File Ref: DN25/0028

**SSD No.** SSD-84862461  
**Address:** 2 Flide Street, Caringbah  
**Proposal:** Redevelopment of existing social housing for the purposes of social and affordable housing – two residential flat buildings.  
**Application Status:** EIS Public Exhibition  
**Proponent:** NSW Land & Housing Corporation (Homes NSW)

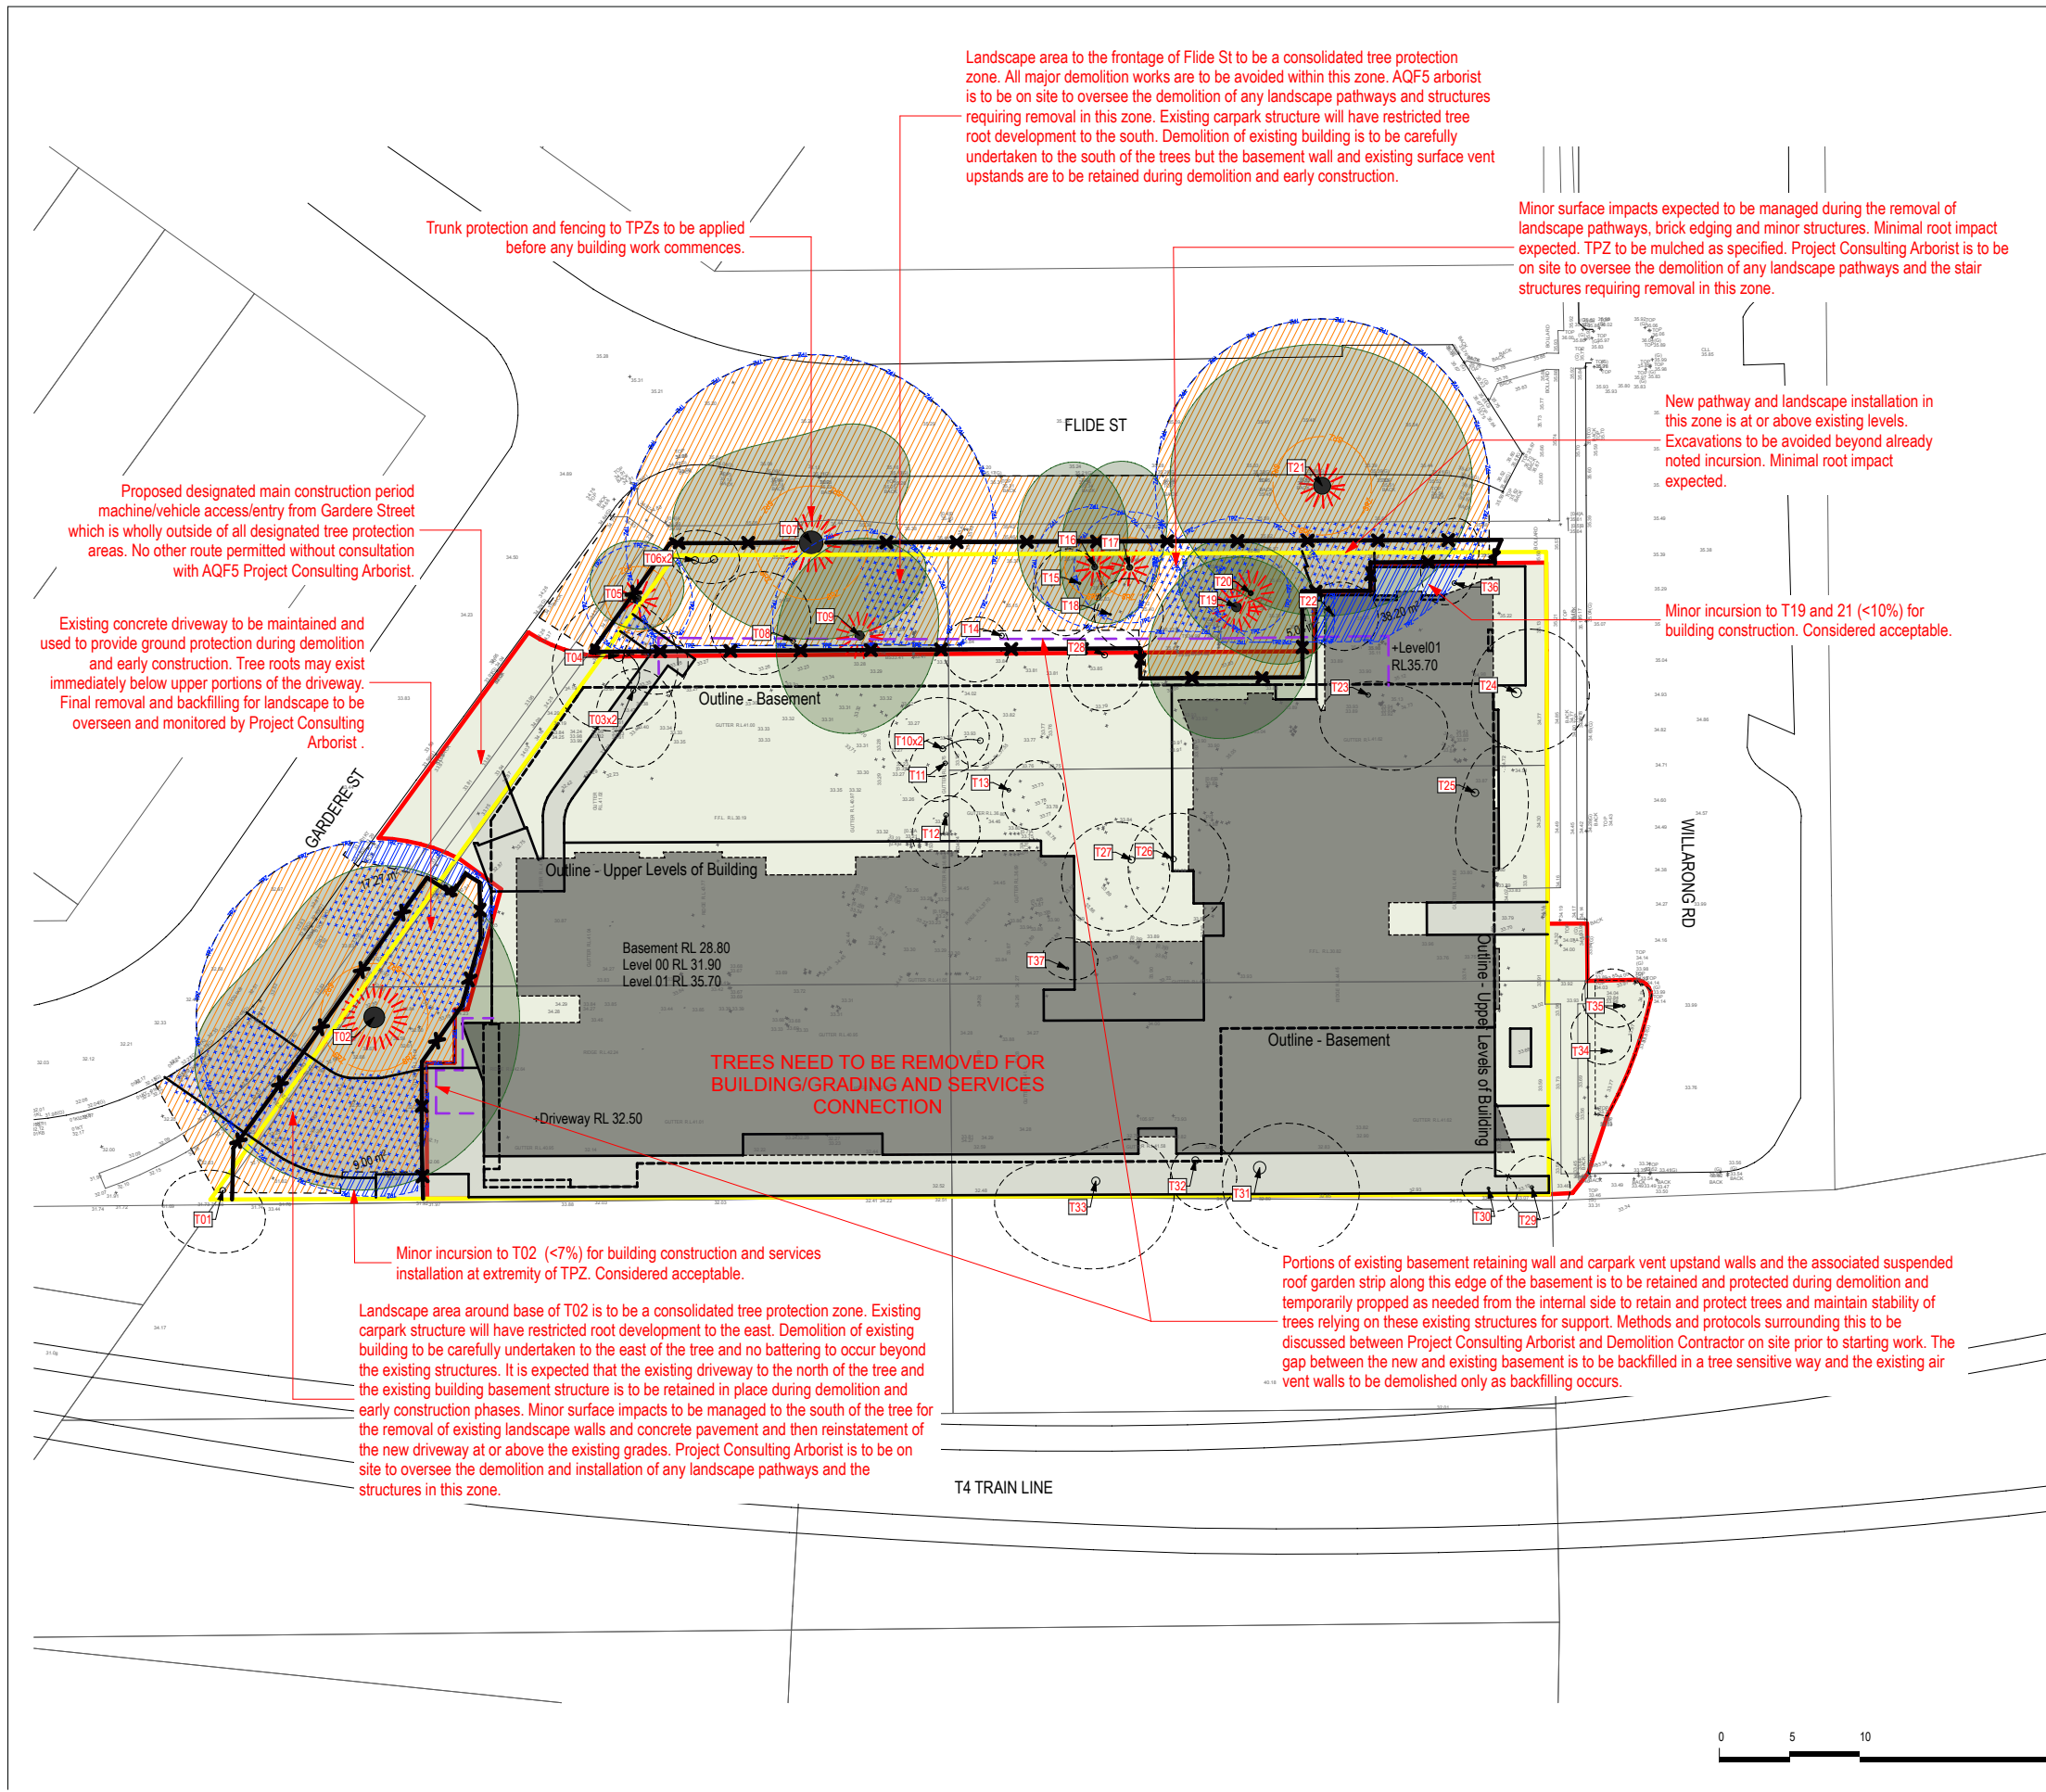
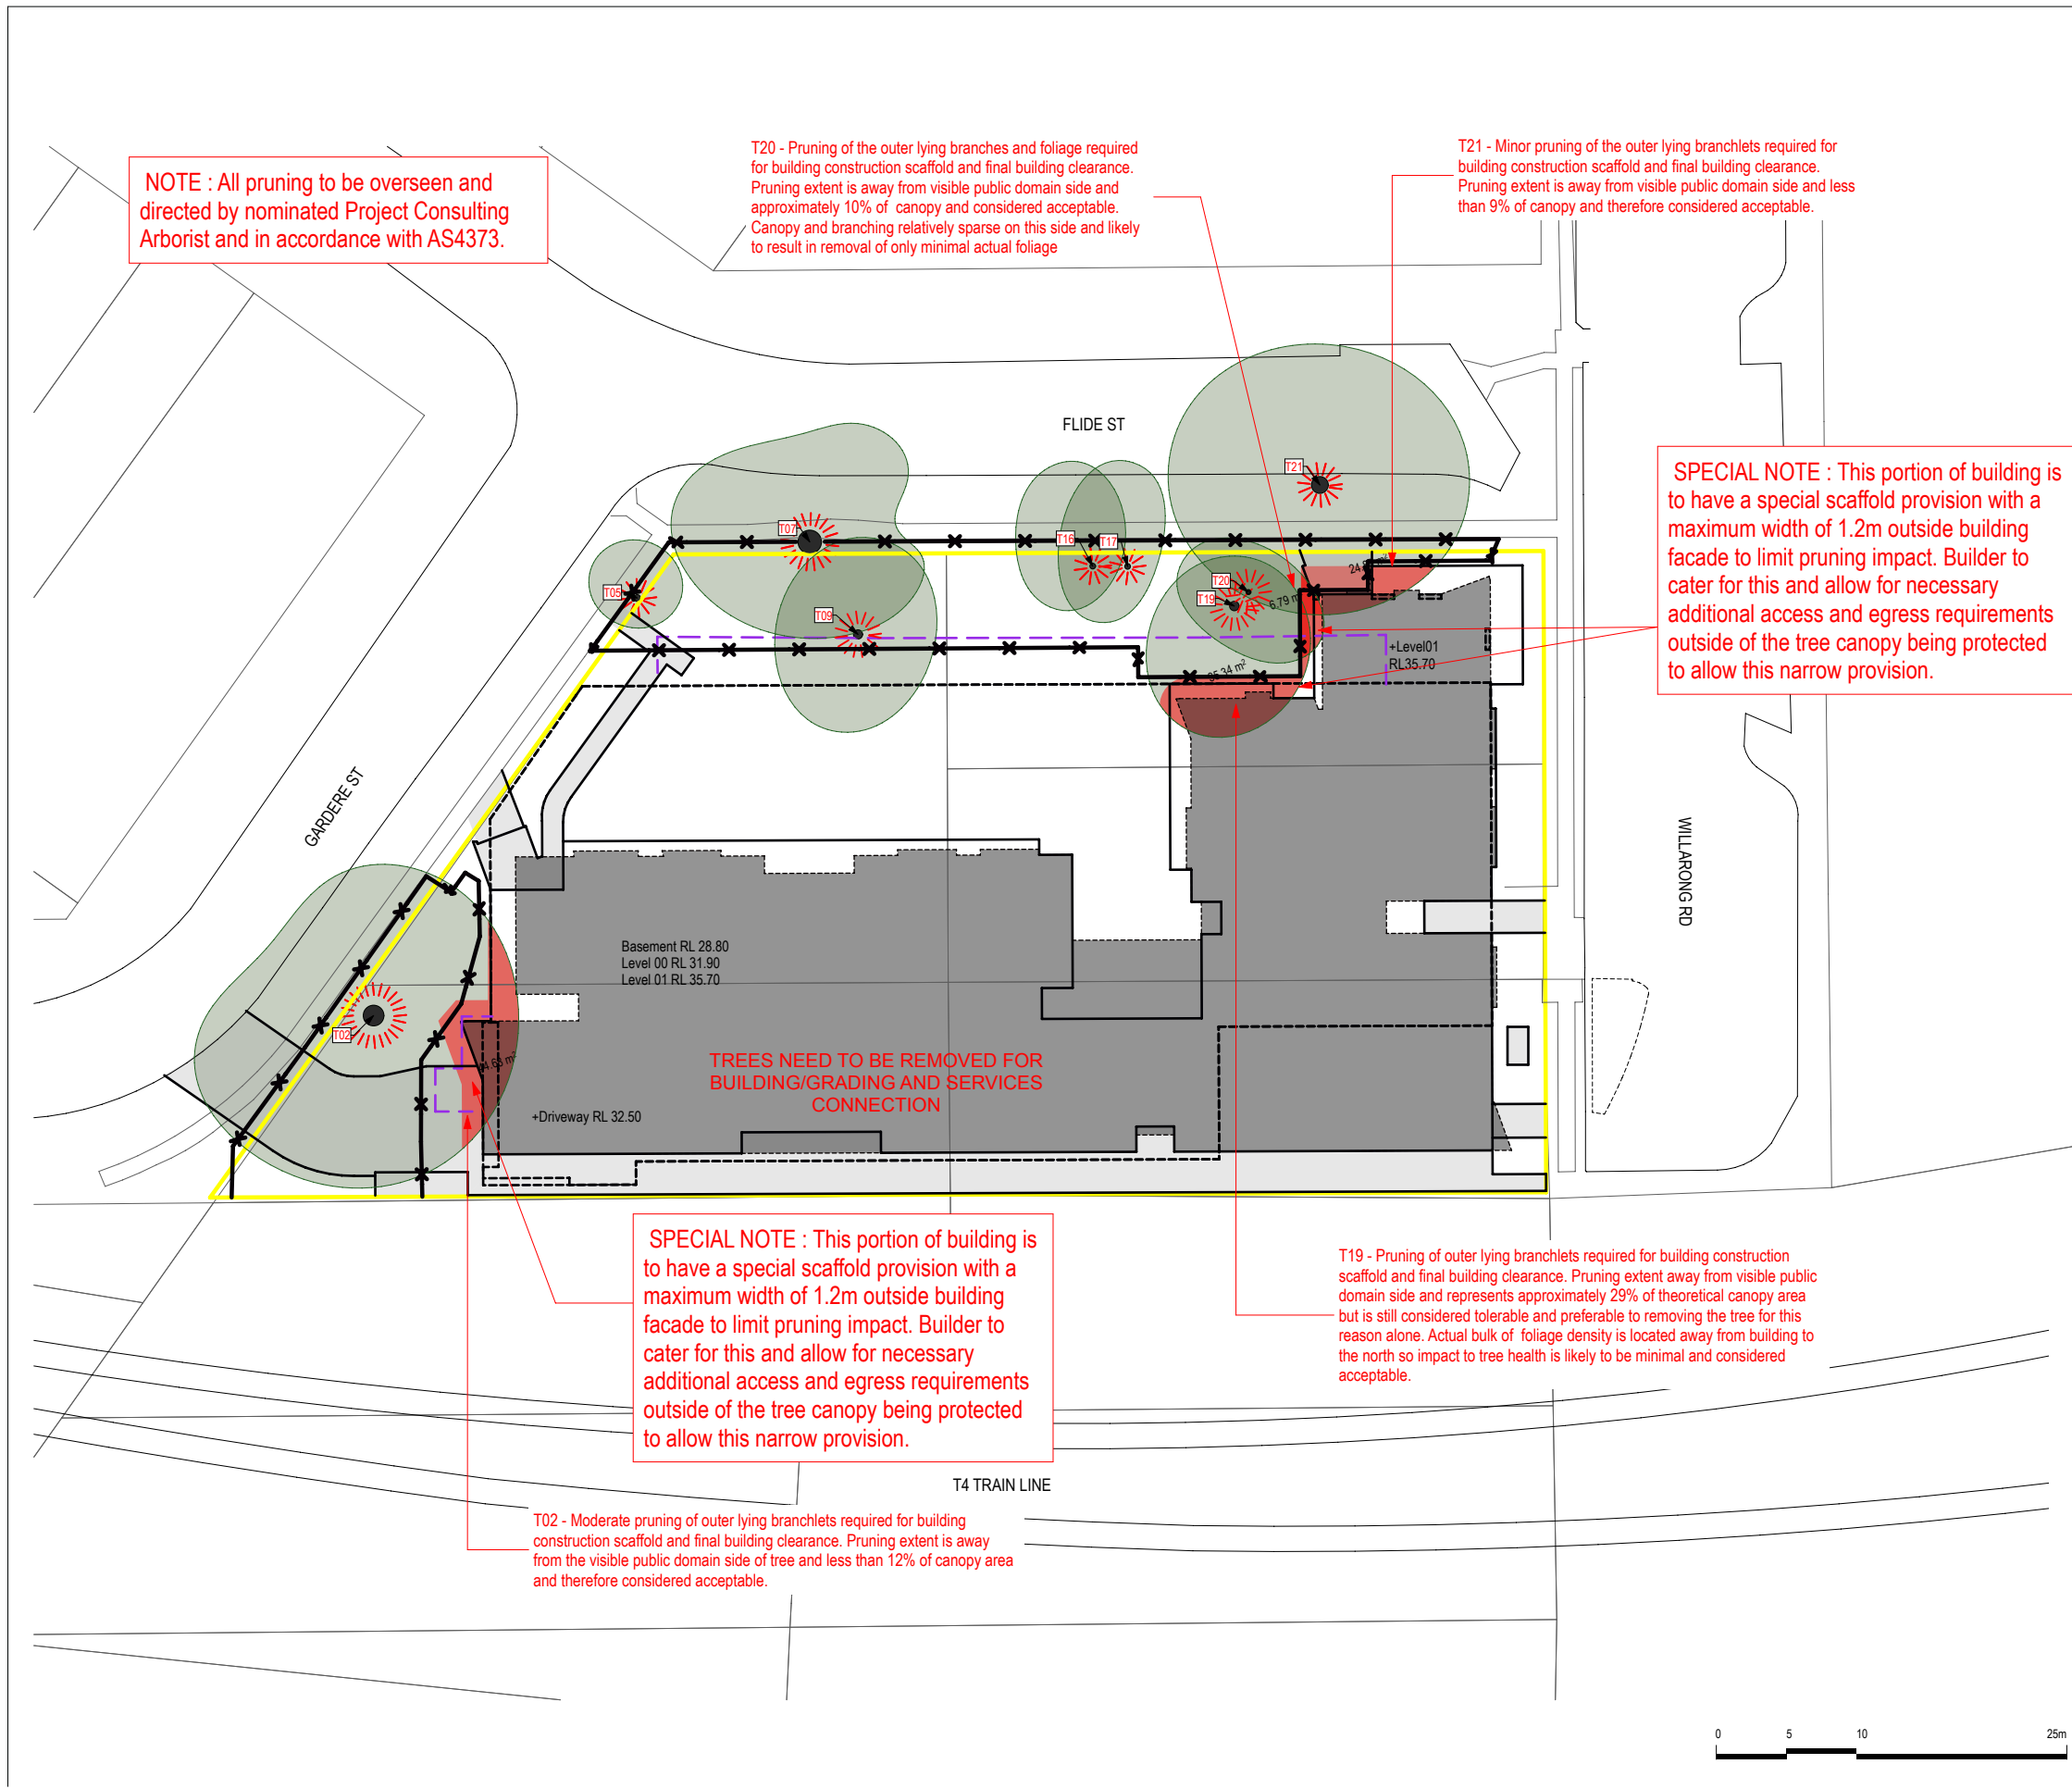
- Solid masonry retaining walls and bench seating within the Tree Protection Zone of Tree 7 needs to be re-considered. Alternate construction methodology under advice from Consulting Arborist may ensure adequate retention.

- Levels around Tree 2 are retained and proposed fill to the North where the existing driveway is located should blend with existing levels to reduce any potential impacts to the tree from excessive fill.
- Arborist recommendations should be followed and arborist supervision during any excavation/works within the Tree Protection Zones of existing trees to be retained.
